COMMENT OF SEPA THRESHOLD DETERMINATION

Kittitas PUD #1 Headquarters SE-26-00003

Subject Parcel: #051833 4271 Kittitas Hwy, Ellensburg, WA

Applicant: Manastash Architecture Planning and Development (MAPD)

C1.0

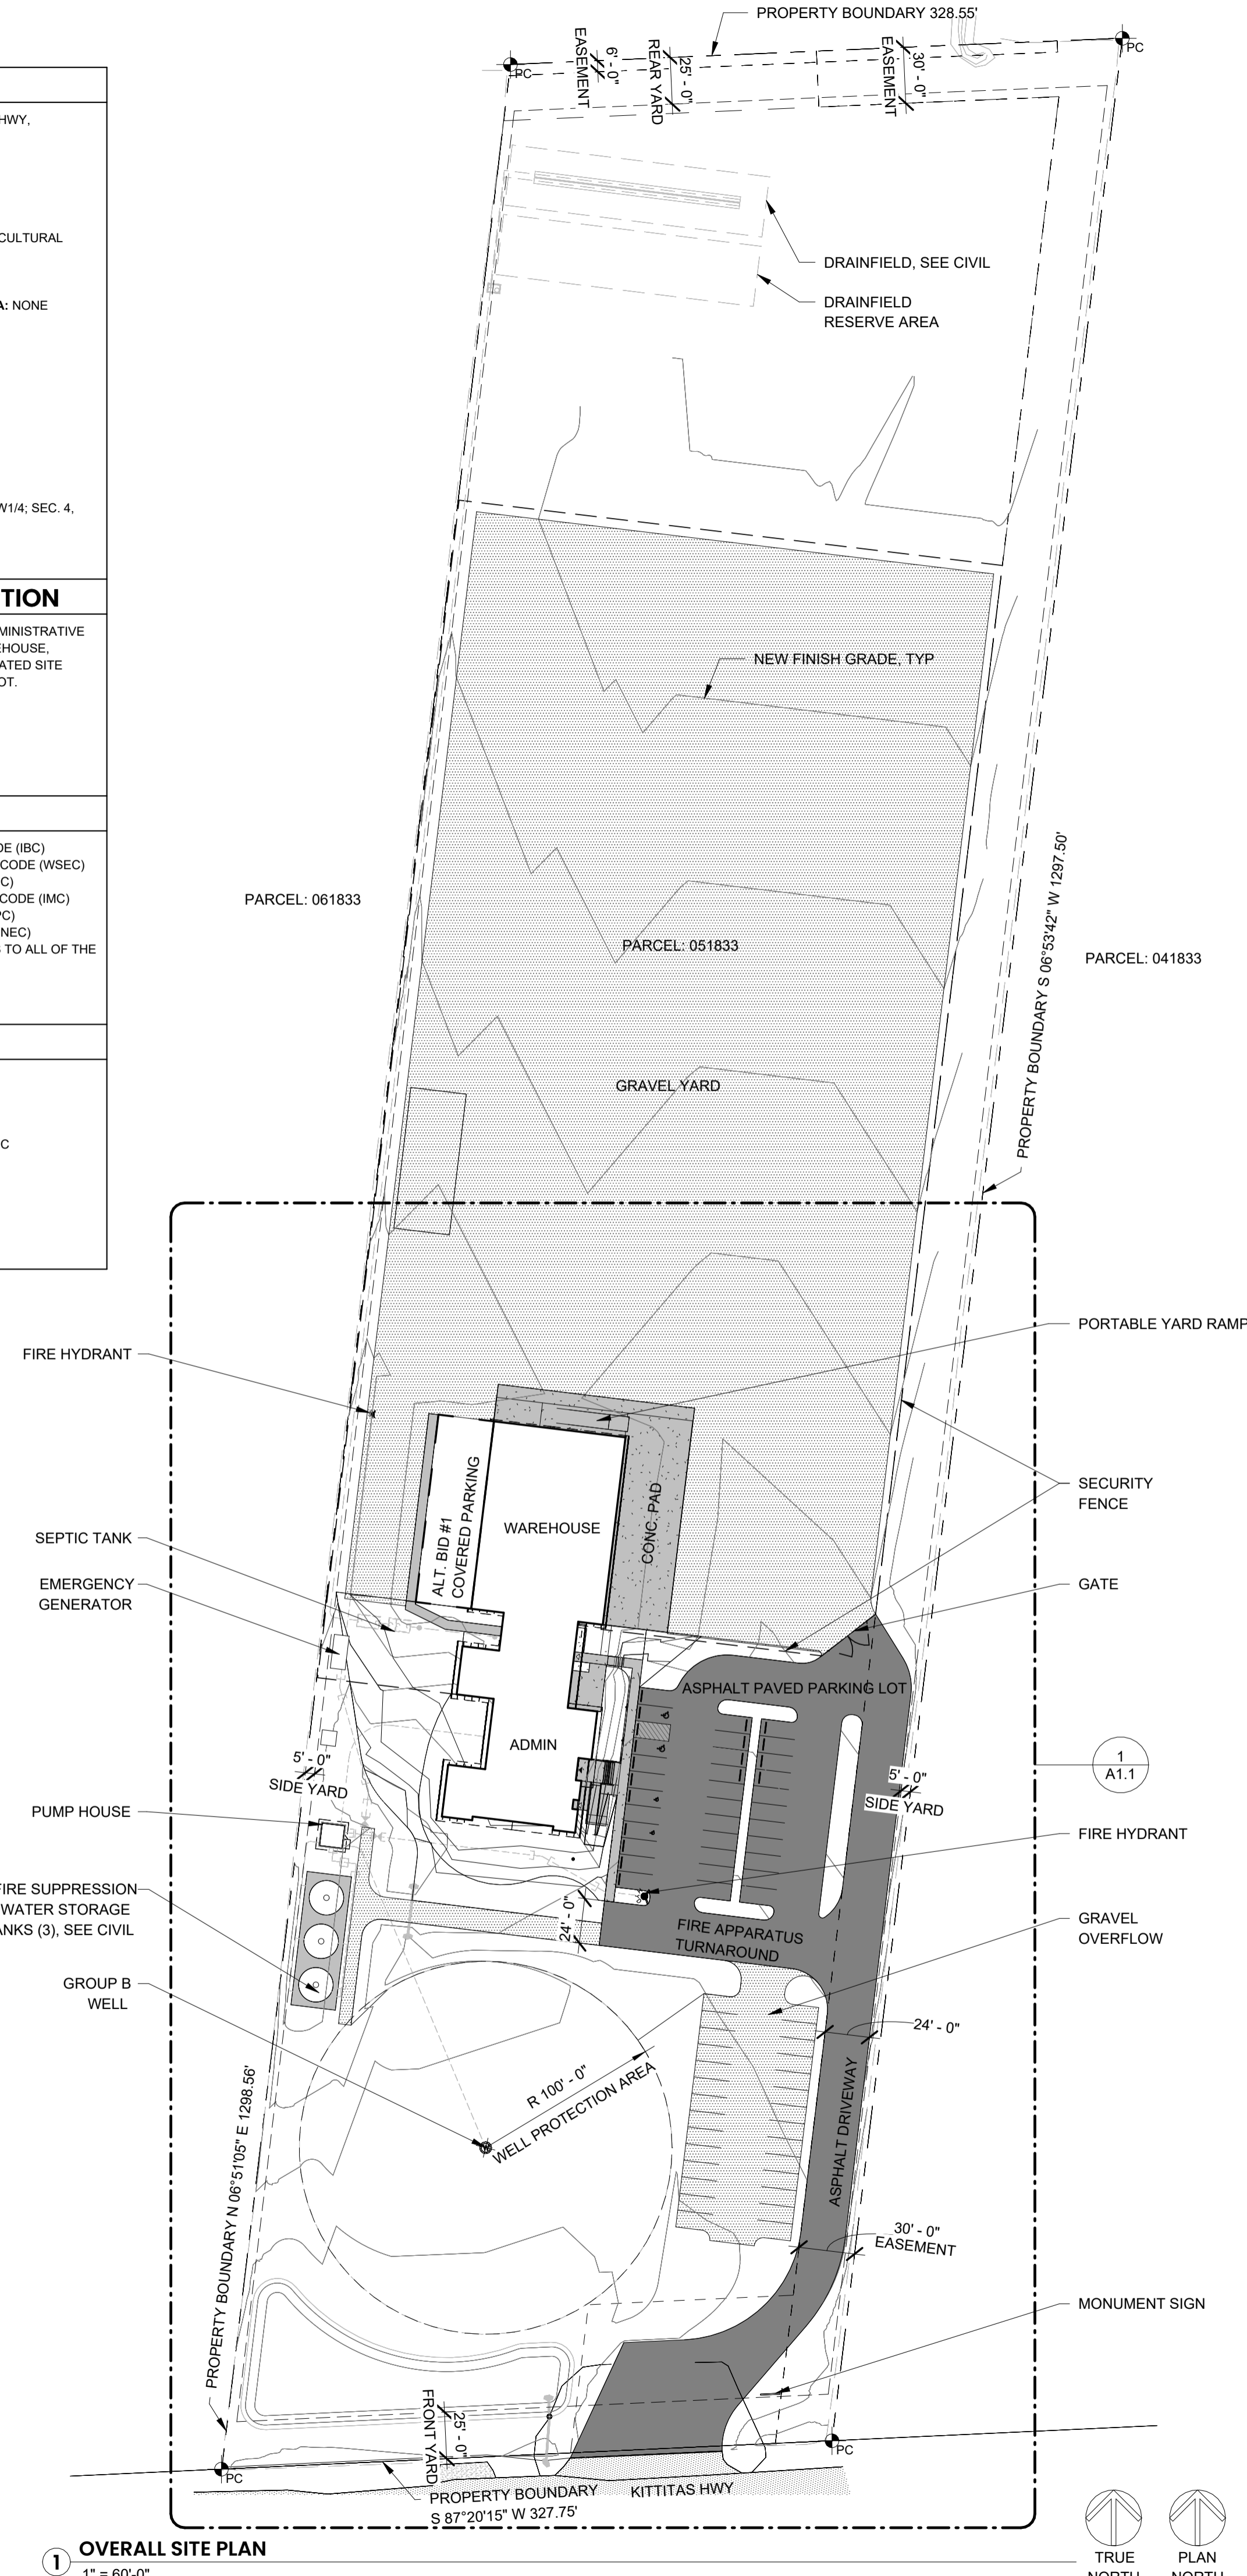
Checklist §B.7.a(3) states “no anticipated hazardous chemicals will be stored, used, or produced.” The site plan (Exhibit E) confirms three 60,000-gallon fire suppression tanks—180,000 gallons of dedicated fire water. Under NFPA 22, tank capacity must “reflect actual fire demand.” That volume is consistent with a facility storing transformer mineral oil (a Class IIIB combustible liquid), diesel fuel, hydraulic fluids, and potentially PCB-containing equipment—not a low-impact administrative office. The Group B well at 275 gpd would take approximately 655 days to fill the three tanks; the water source for the fire system is not disclosed. Analyzed in Section VIII. Controlling authority: Norway Hill Preservation & Protection Ass’n v. King County Council, 87 Wn.2d 267 (1976) (hard-look standard); Ellensburg Cement Products, Inc. v. Kittitas County, 179 Wn.2d 737 (2014) (DNS reversed for industrial use on A-20 in this same County).

Exhibit E (Overall Site Plan A1.0 / C1.0) shows a 6,300 sf administration building, a 10,200 sf pre-engineered materials warehouse, a large fenced equipment and materials yard, two (or three) 60,000-gallon fire suppression water tanks, an emergency generator, a Group B well and pump house, a septic tank with drainfield and reserve area at the north end, a portable yard ramp, and approximately 53.5% total impervious coverage. The project narrative and public notice nevertheless frame the proposal as a low-impact "administrative facility."

Farmer Stakeholder's adjacent parcel contains a known chronically wet area at the terminus of the shared 30-foot easement. Exhibit E locates the primary drainfield and drainfield reserve area at the extreme north end of the subject parcel directly adjacent to this wet zone. Exhibit F (Critical Areas) shows a PSS1A palustrine scrub-shrub wetland and mapped hydrologic features in the immediate vicinity. No hydrogeologic analysis, effluent migration analysis, or seasonal saturation study has been provided.

Exhibit E depicts the PUD’s paved access and circulation surface within the 30-foot easement as approximately 25 feet wide, with a perimeter security fence running alongside the paved strip on the PUD side. Five feet of the recorded 30-foot easement is thereby converted from usable agricultural travel width to an unpaved shoulder pinched between the fence and the paved edge. For a haying operation, that five-foot reduction is not cosmetic: modern haying equipment routinely exceeds 12 feet in transport width, and oversized loads such as stacked bale wagons commonly require the full width of a 30-foot easement plus overhang tolerance to navigate without damage. The checklist does not disclose the actual paved width, the fence setback, the effective functional clearance, or any analysis of whether common haying equipment can operate within it.

Exhibit E shows that the PUD parcel comes to a sharp corner at its northeast boundary along the line where the easement and Farmer Stakeholder's field meet. Agricultural equipment making the turn into or out of the field at that corner routinely overhangs the fence line. A rigid perimeter security fence at that corner, installed tight to the pavement edge, converts overhang tolerance into a hard stop: any implement that extends beyond the tractor profile will strike the fence. In practical terms, the sharp-corner geometry plus a rigid fence on the PUD side closes the turn for any equipment larger than a light tractor. No turning-movement analysis, equipment clearance envelope, or fence placement analysis appears in the SEPA record.

Drawing file: SE-26-00003 Kittitas PUD 1 HQ / SE-26-00003 Kittitas PUD 1 HQ - Staff Map - Aerial View.pdf

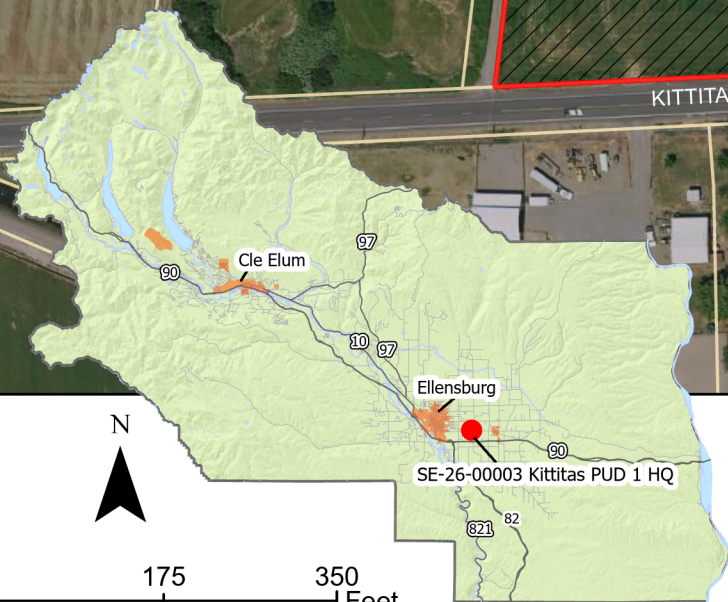
The County’s own aerial imagery (Exhibit B) and land use map (Exhibit H, designating the parcel “Rural Working”) show the parcel embedded within a continuous, actively farmed landscape. The parcel immediately to the north Farmer Stakeholder’s property is in active alfalfa production. Characterizing the site as “former” agricultural land understates baseline conditions and the nature of the conversion.

A1.0

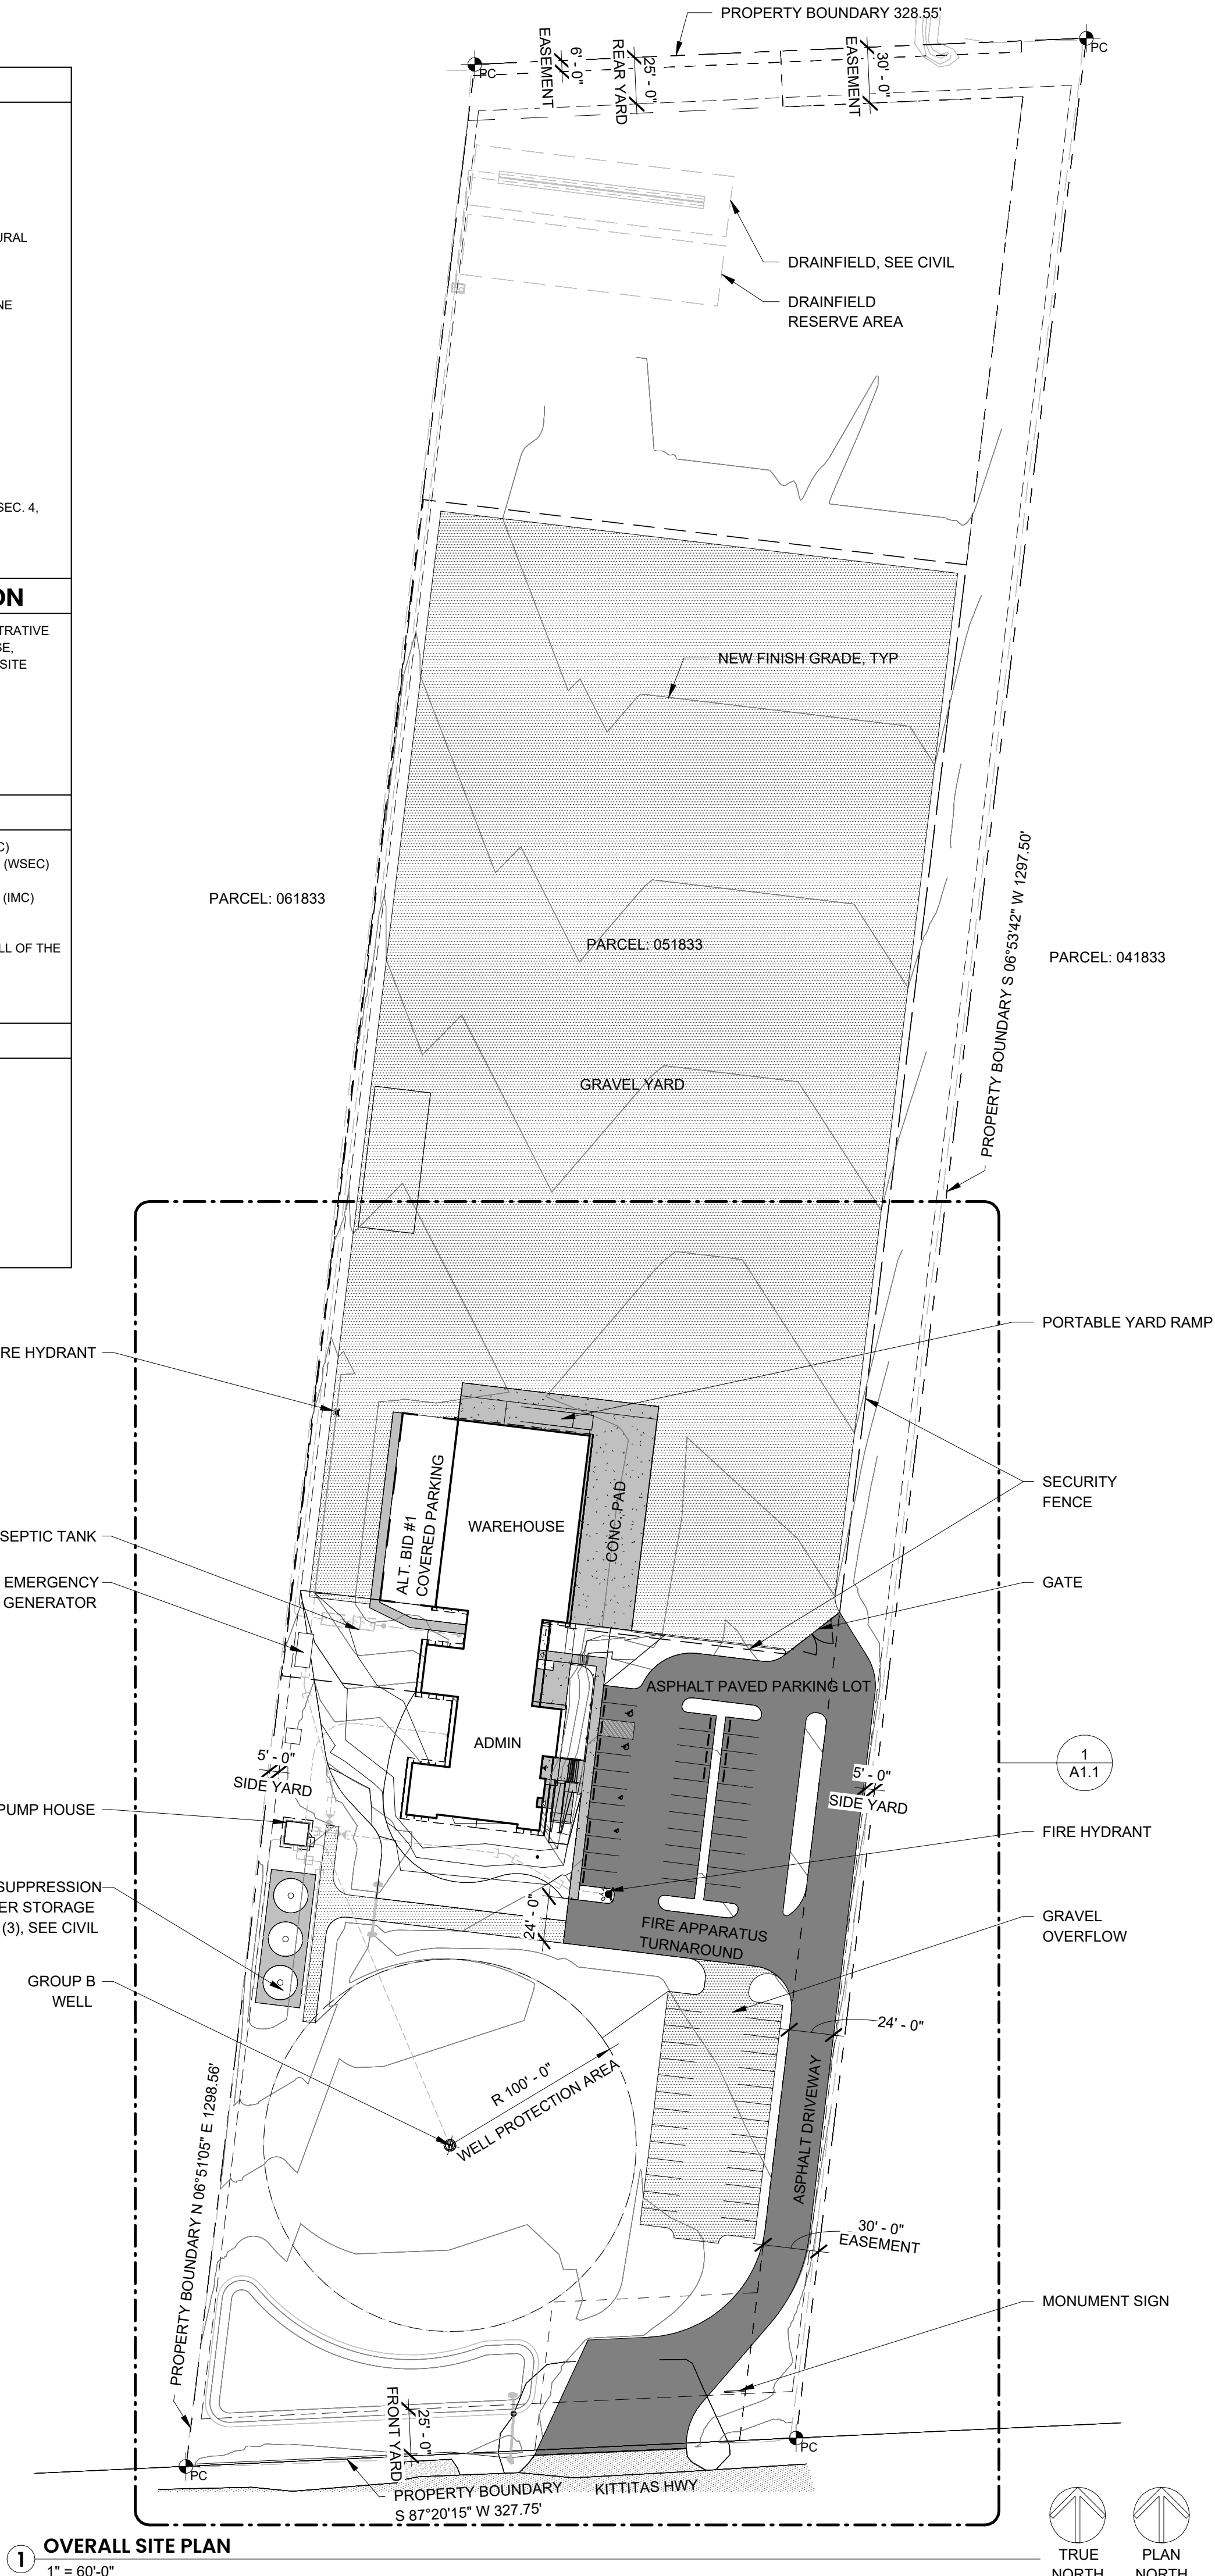
The site plan (Exhibit E) allocates zero acres of the 9.65-acre parcel to designed greenspace, landscape buffers, working agriculture, or native vegetation. The dominant land use is a 5.79-acre industrial gravel yard (60% of the parcel) with no visual screening between the PUD operation and Farmer Stakeholder’s adjacent active hayfield, no street-frontage landscaping along Kittitas Highway, and no internal vegetation of any kind. The 30-foot agricultural easement along the eastern boundary is encumbered land within the PUD parcel that cannot be counted as project greenspace under any methodology. By contrast, a typical single-family residence on a comparable 10-acre rural parcel in Kittitas County leaves 80–90 percent of the ground in a combination of pasture, hay, garden, ornamental landscape, trees, and native vegetation—the configuration the County’s comprehensive plan designates as “Rural Working.” A site plan with zero greenspace cannot satisfy the comprehensive plan’s “Rural Working” designation, the GMA’s open-space and natural-resource goals at RCW 36.70A.020(8)–(10), or the KCC 17.60A conditional-use compatibility requirement that mitigation include “landscape buffers, special setbacks, screening, and/or site design using physical features.” Analyzed in Section V.L. Controlling authorities: WAC 197-11-444 (land use, plants, animals, aesthetics, and recreation as enumerated elements of the environment); RCW 36.70A.020 (GMA planning goals); KCC 17.60A (conditional-use compatibility findings).

Exhibit E shows perimeter security lighting, an industrial yard layout, 24/7 fire-suppression infrastructure, and pole-mounted lighting across the yard and parking areas. No lighting plan, photometric study, or noise analysis has been provided, despite the proximity of Farmer Stakeholder's residence and short-term rental use to the east.

The site plan (Exhibit E) proposes a stormwater detention pond to collect runoff from approximately 53.5% impervious coverage, including the gravel yard where vehicles, transformers, and maintenance equipment will be stored. That runoff which may carry petroleum residues, de-icing materials, and transformer-area residues will discharge into the same County ditch infrastructure that carries irrigation tailwater serving adjacent farm parcels. The checklist

SE-26-00003 Kittitas PUD 1 HQ Land Use

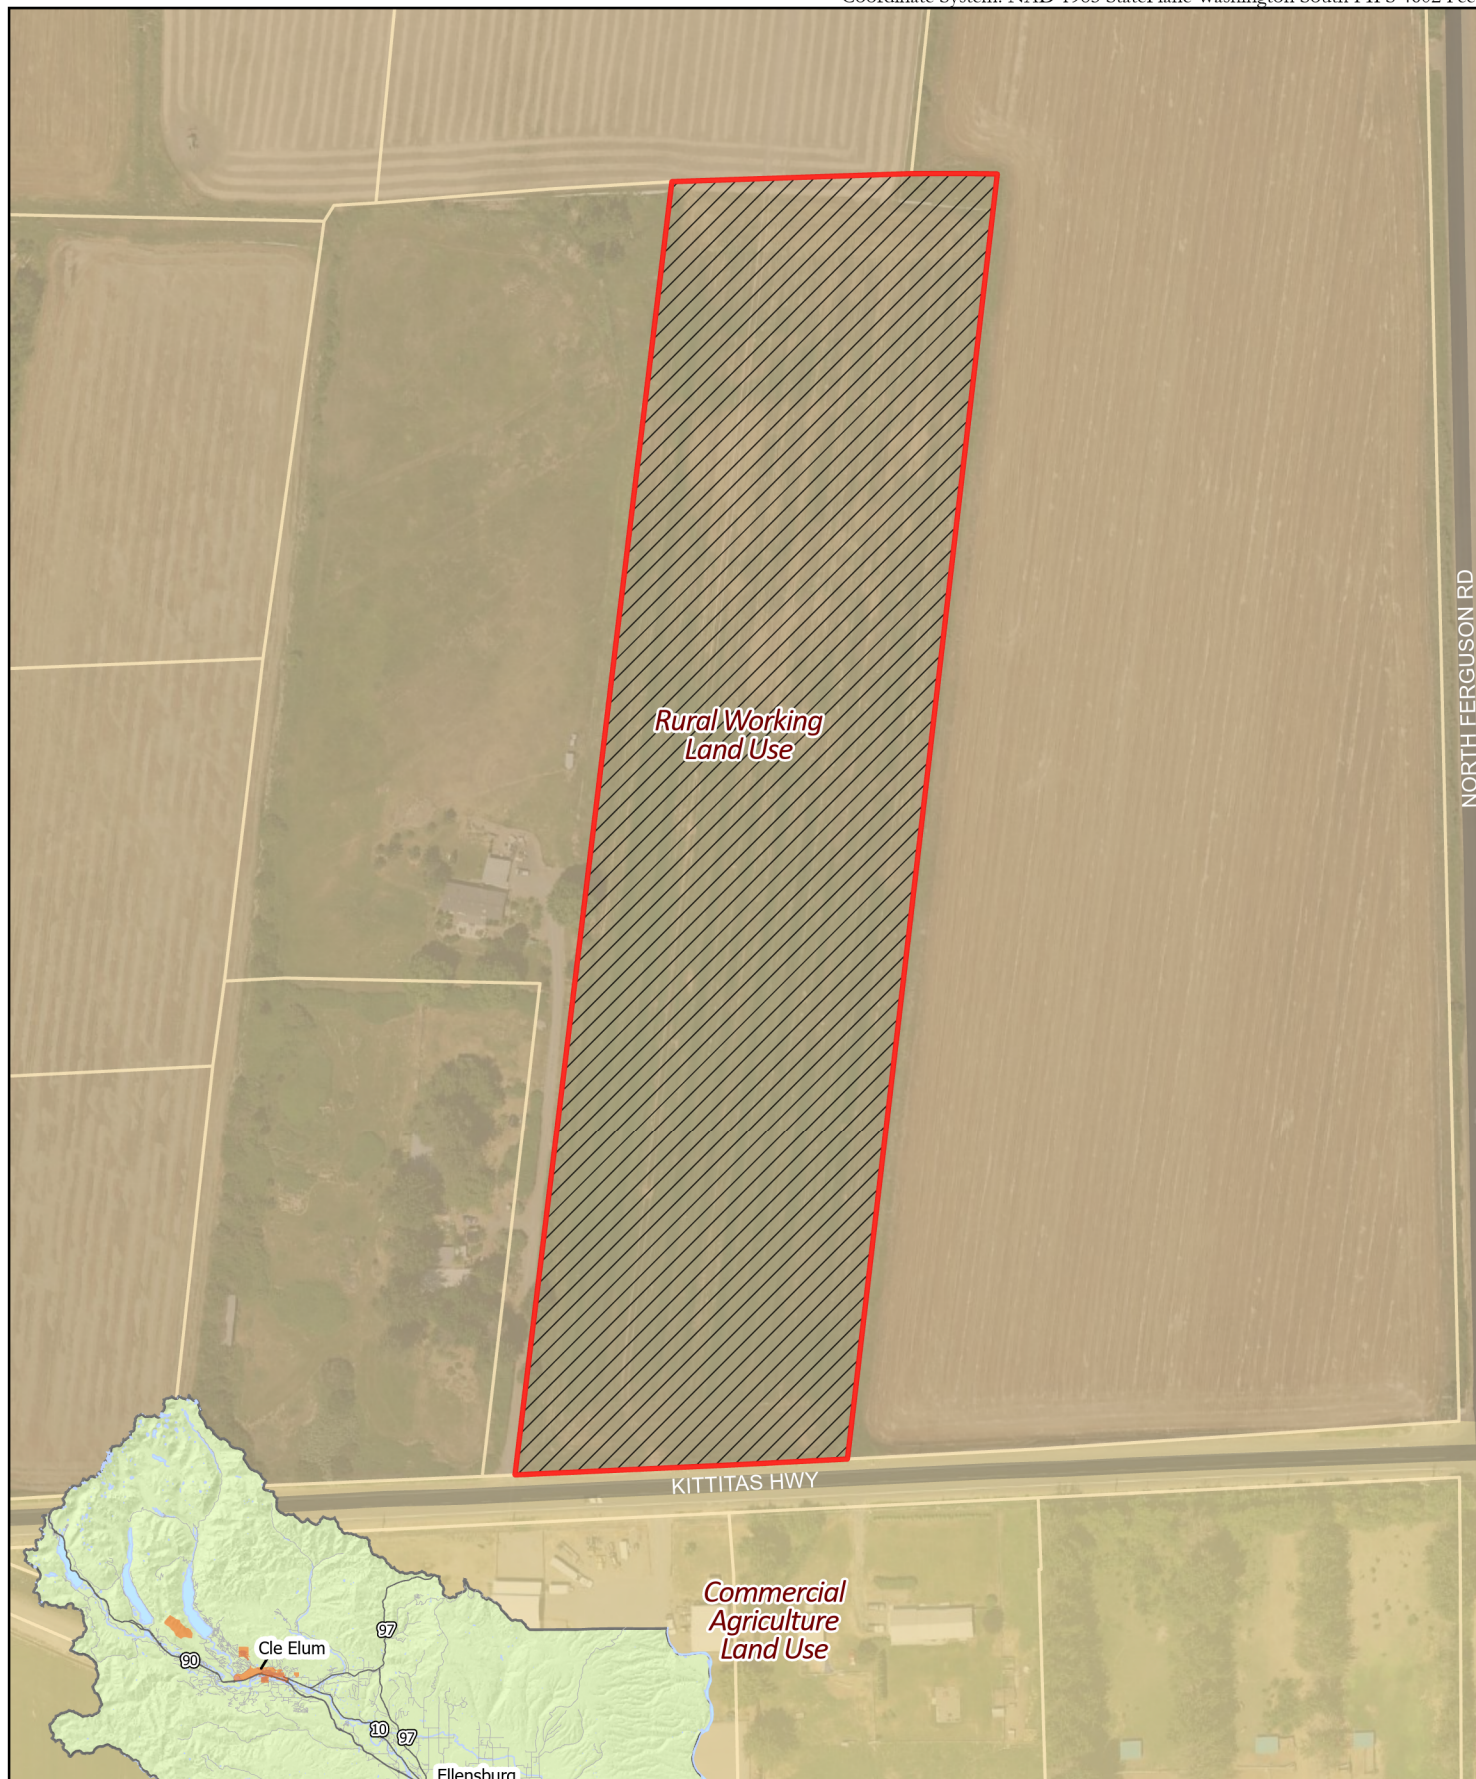
Here, the parcel is actively farmed and designated “Rural Working” (Exhibit H). The checklist’s characterization of “former” agricultural land and “no impacts” to surrounding farm operations is contradicted by the County’s own mapping. A DNS issued on that record would be clearly erroneous within the meaning of *Norway Hill*.
